Application No: AW/246/20/HH
Site Address: 14 Regis Avenue Aldwick PO21 4HQ
Description of works: Front porch extension and front extension to existing garage including raising height of garage roof.

Thank you for your internet representation made on 16th October 2020 which has been recorded as an objection with the comments as follows:

PROPOSED PORCH AND GARAGE EXTENSIONS AT 14, REGIS AVE., ALDWICK
FOR MR. J. EVANS.

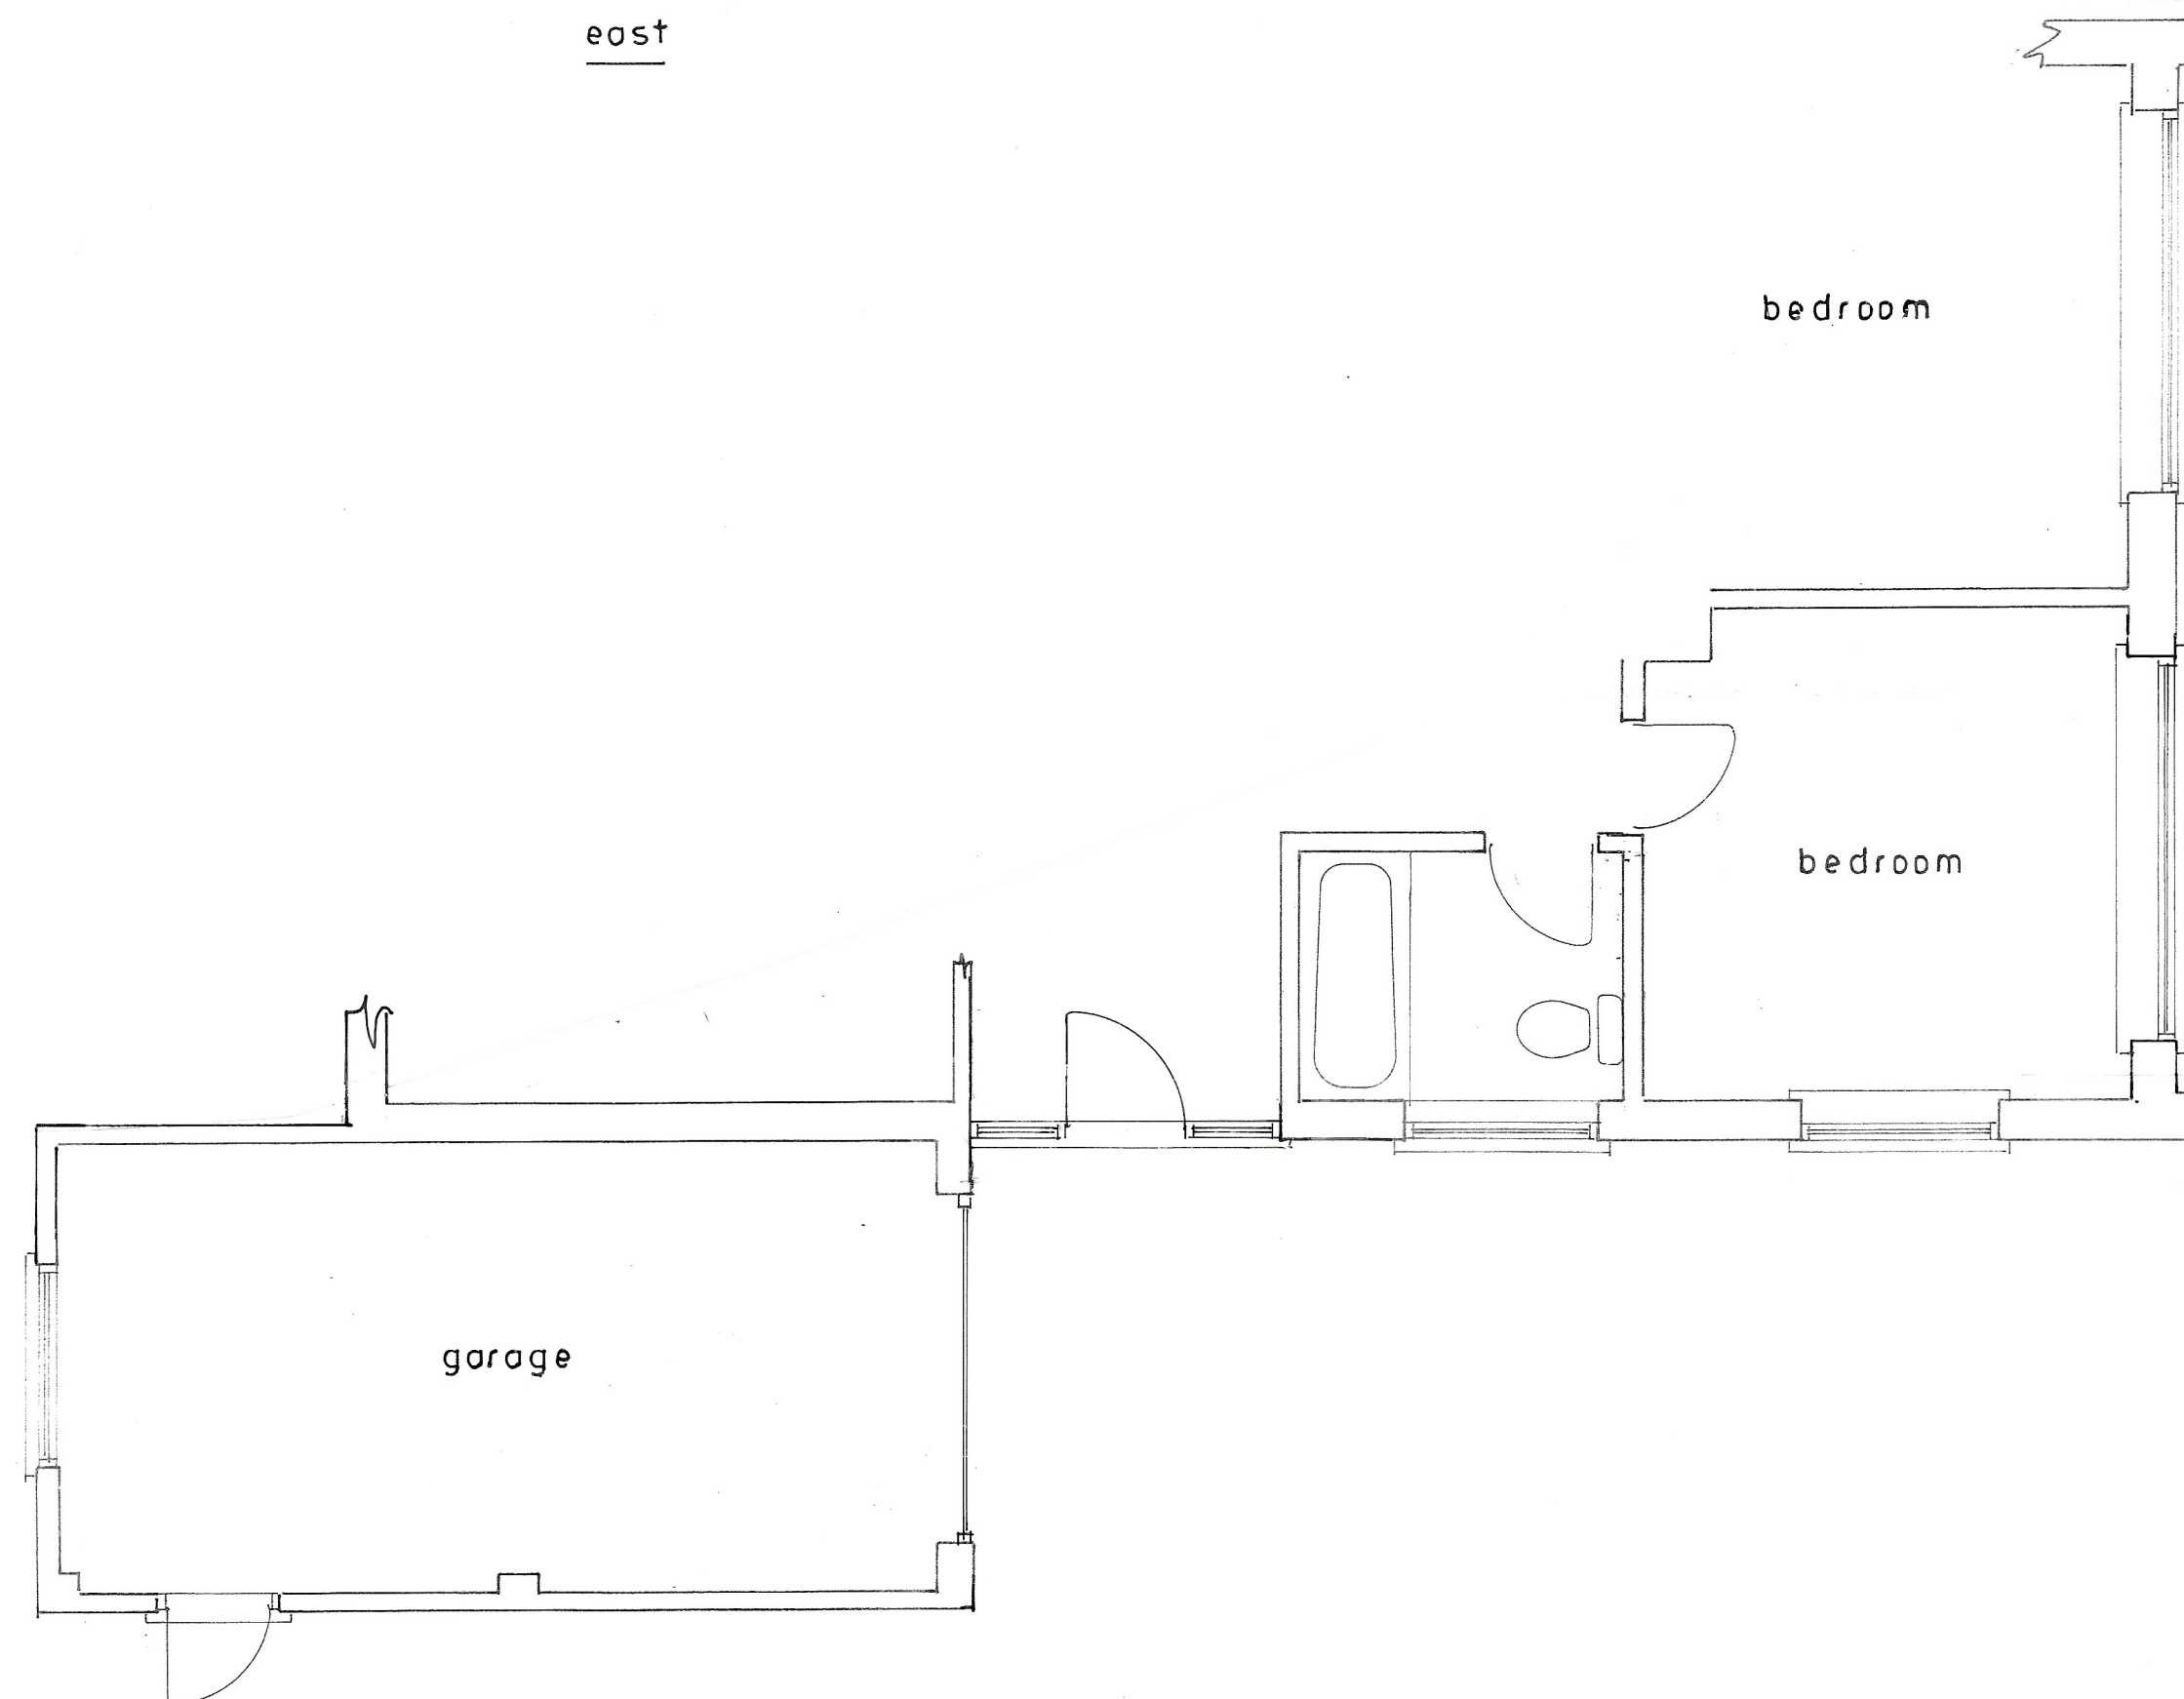
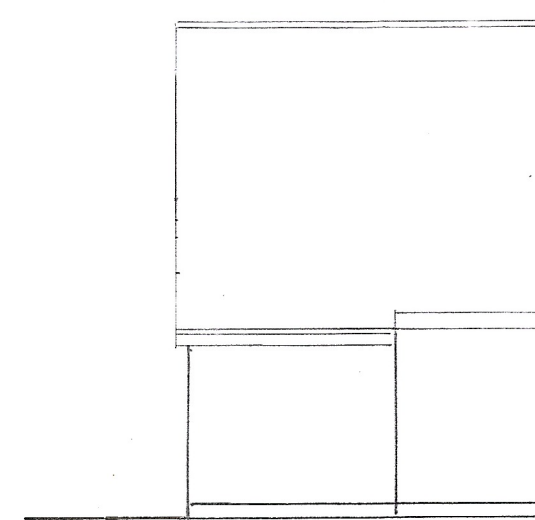
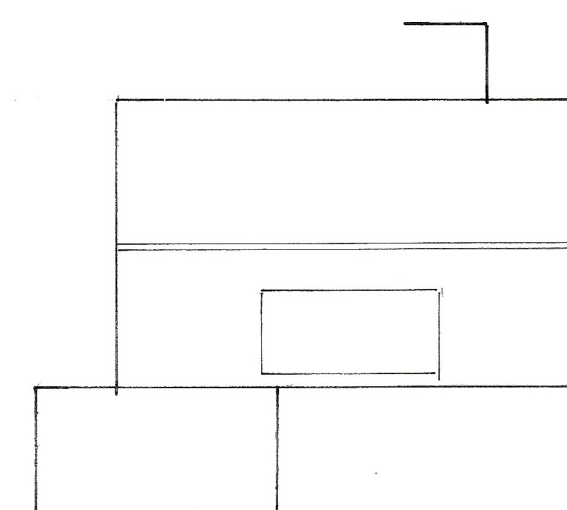
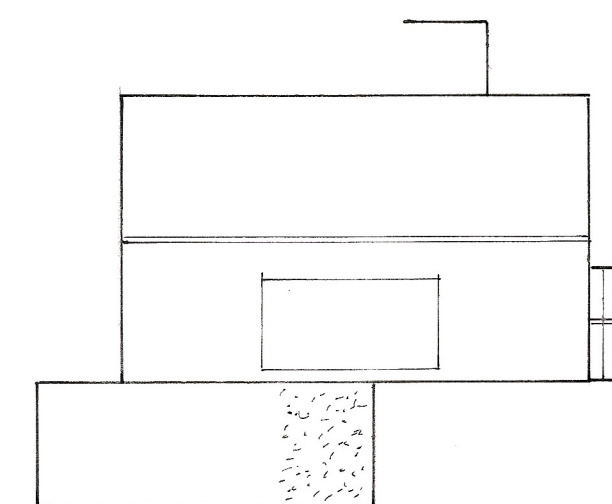
After looking at the plans for the proposed garage extension the wall of which would project opposite our lounge window and block out our light because the height of the wall would be above our eaves level as we live in a chalet style house. This would negate any benefit from having the window which was there when the house was built in the 60's.

Secondly, we are concerned about the close proximity of the proposed foundations to our waste water and sewer pipes especially the vibration set up during excavations and the distinct possibility of cracking from this work. These pipes are glazed earthenware which are brittle by their very nature and are nearly 60 years old. We are worried about a smaller waste pipe from our kitchen which runs under and across our lounge to connect with the sewer pipe via a gully, we are in for big trouble if this pipe becomes dislodged as a result of the proposed works.
